Introduction OVERVIEW

3.2 SITE ACCESS DESIGN AND VISIBILITY SPLAYS

5 SUMMARY

SITE ACCESS ARRANGEMENT & VISIBILITY SPLAYS

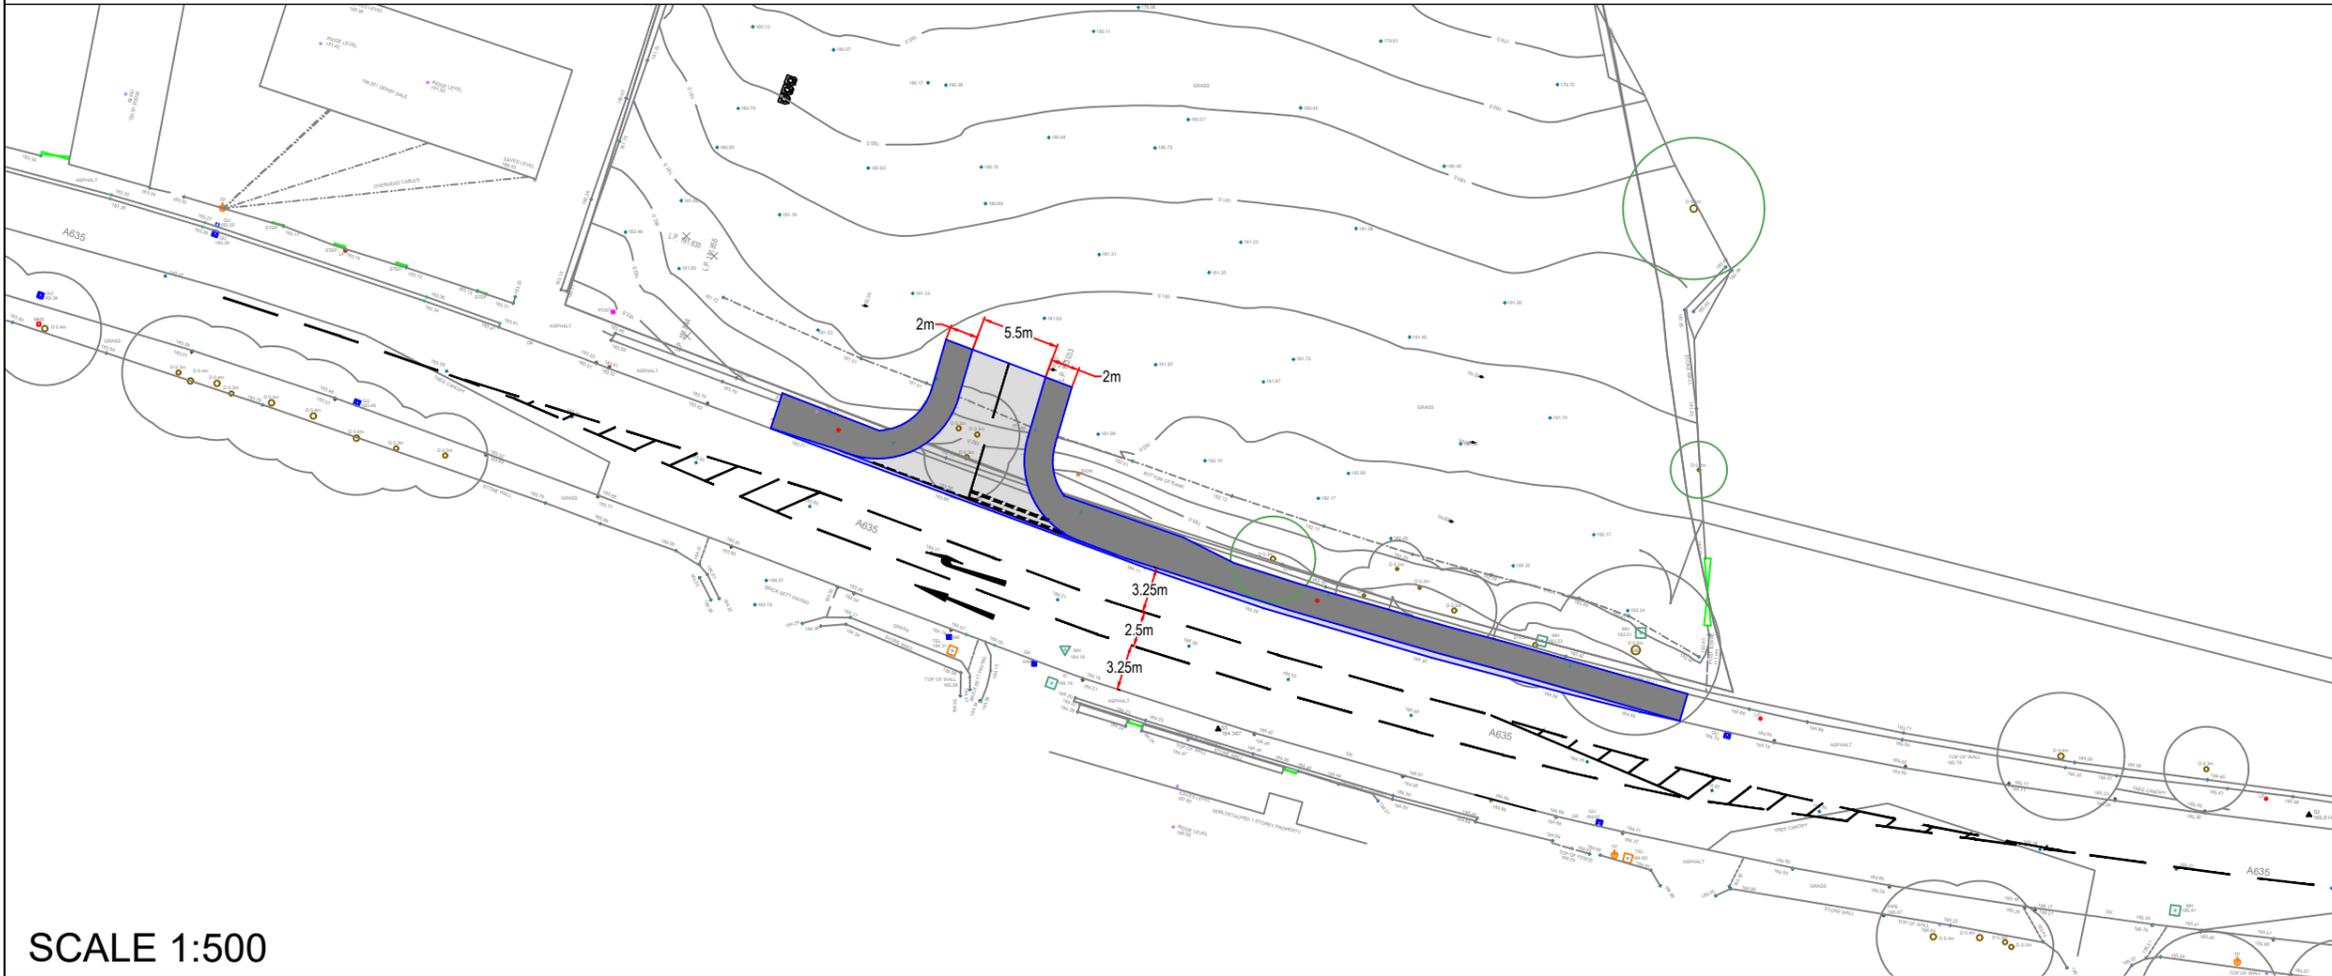
Where this island is proposed there is an existing gated access point into the land

So this proposal is doomed to failure

The report recommends to lessen the width of the refuge from a standard 1.5m to 1.2m; they ignore that the report is also encouraging walking, so the proposed refuge, there to encourage it use and when day-walkers cross over looking for the southern path way, it leads to a footpath dead-end then they will crossover at the junction of the new development

The report fails to take into account that a bus stop will impede visibility, for vehicles exiting the proposed new junction

The report misses the access, that will prevent an island being created

Visibility splays, the report recommends *to build to less than the desired standard, plus requests a departure relaxation* ... this is unacceptable. Whom takes the legal responsibility, should any accident occur?

The report recommends to lessen the width of the refuge from a standard 1.5m to 1.2m, it is not acceptable to lessen standards in this matter
